Recommendation: Refuse

Applicant: Mr Harry Blackwell

Proposal: Build a timber frame building within the existing pole barn building. This will make a two bay garage, shed and boiler room, ancillary to the main house. Home office, storage and mezzanine to the first floor.

Drawing No - 007
North Elevation

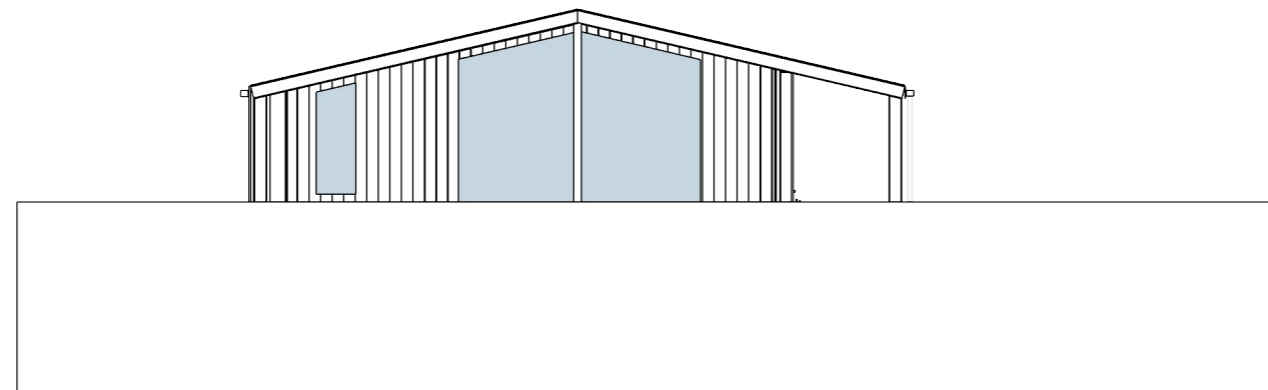
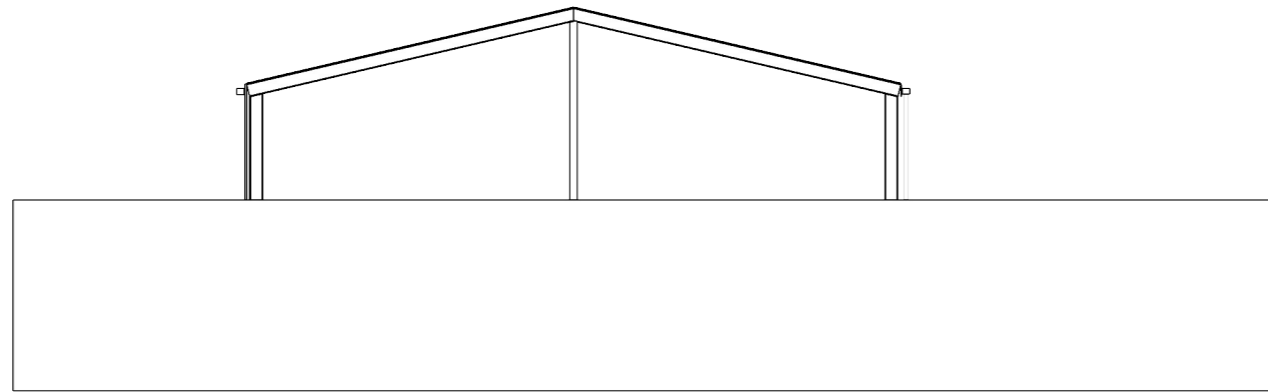
There are windows proposed to the north, south and west elevations, which result in a highly modern design approach. The windows, together with the cladding, create a stark design approach that would appear unduly obvious in the streetscene.

There is a balcony area to the northern boundary, which would not be set significantly above the land, due to the levels in the area. This element is set in from the sides of the building by 1m, and would not result in any overlooking due to the level change in the area.

Drawing No - 002
First Floor Plan

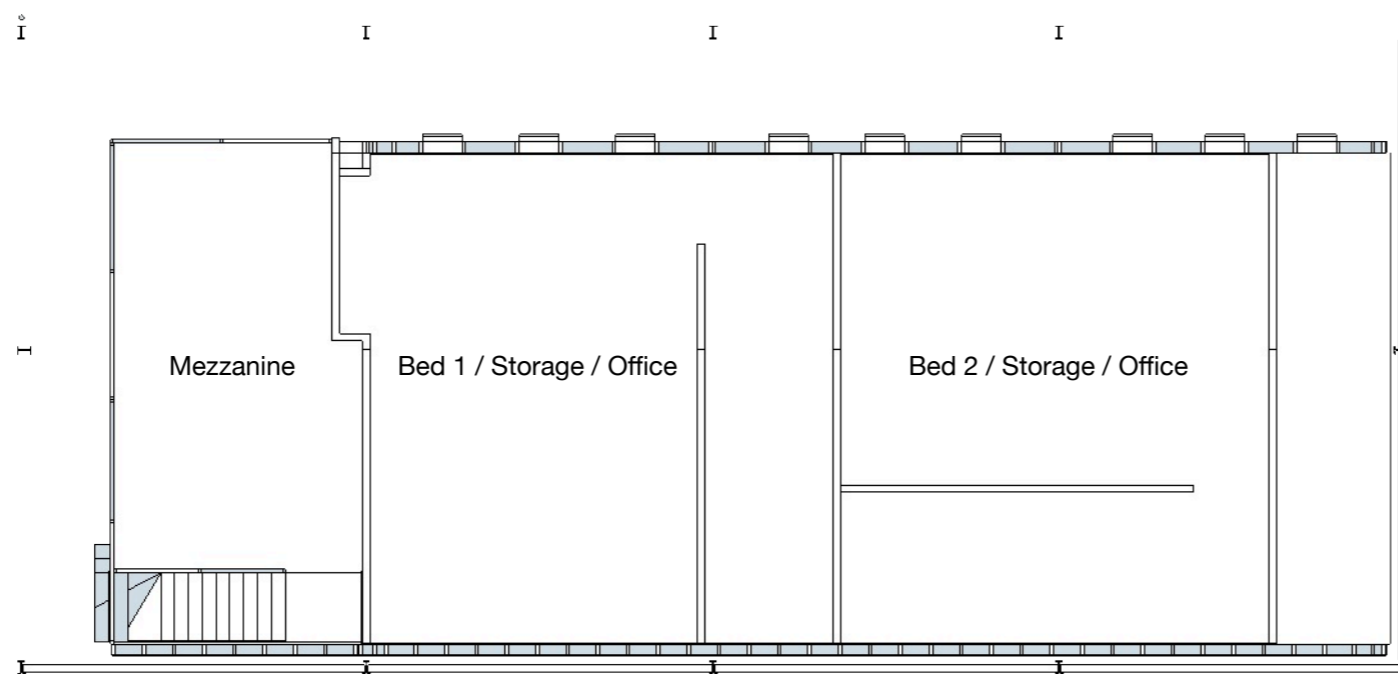
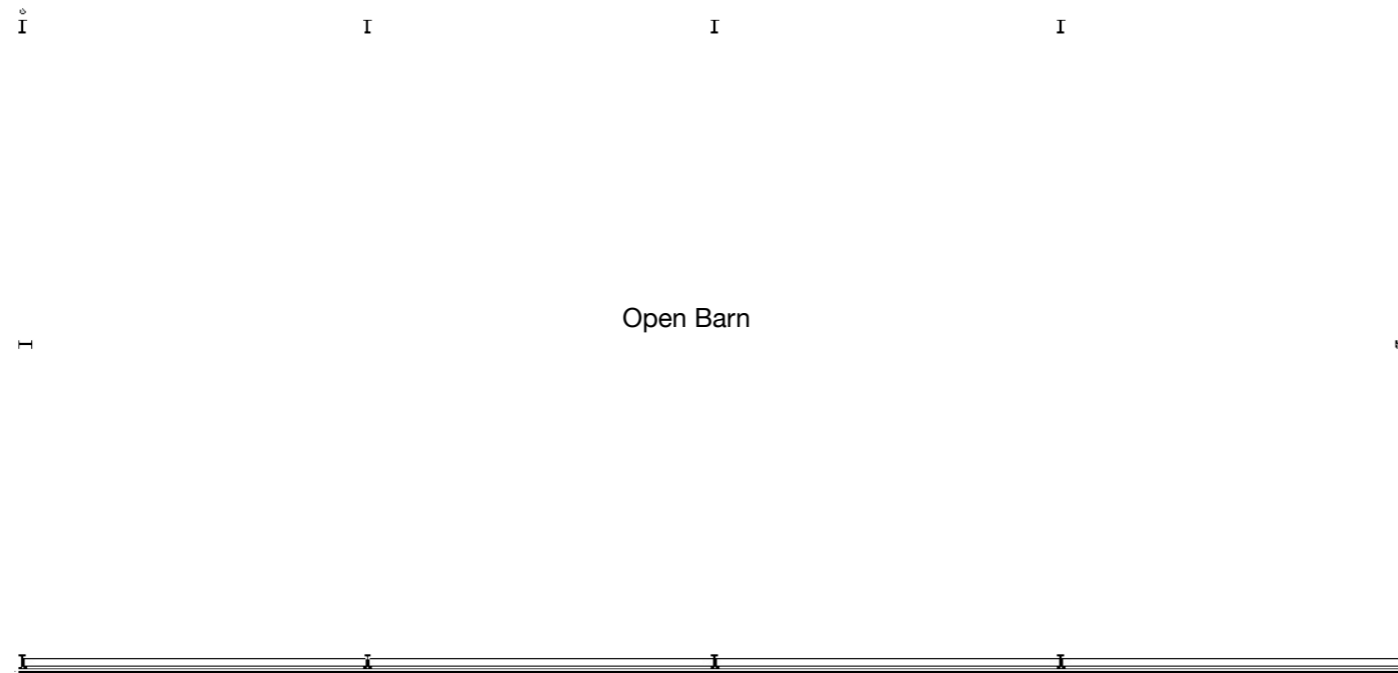
The proposed development has a mezzanine to the south of the site. The proposed mezzanine is 2.8m by 5.6m, and would be covered by the roof of the barn and set in from the eastern wall by 1.1m.

The position of the eastern wall beyond the mezzanine helps to provide a privacy screen to the rear garden and dwelling at Mawles Farmhouse, to the south-east. However, due to the size of the mezzanine and the level change, there would be overlooking and the perception of overlooking to the private garden and dwelling. The size and position of the mezzanine could be used in a similar way as a balcony, which results in prolonged dwell times. For these reasons, this arrangement results in a detrimental impact to the amenity of the adjacent neighbour.

2. By reason of the scale, siting and design of the southern mezzanine, the proposal would result in a detrimental impact to the living conditions of the dwelling and garden of the neighbouring dwelling to the south-east, Mawles Farmhouse, due to direct and perceived overlooking for prolonged periods of time. The harm identified is exacerbated by the change in levels. The proposed development is therefore contrary to Policy ESD15 of the Cherwell Local Plan 2011-2031 Part 1, saved Policy C30 of the Cherwell Local Plan 1996, the Council's Home Extensions & Alterations Design Guide March 2007 and Government guidance contained within the National Planning Policy Framework.
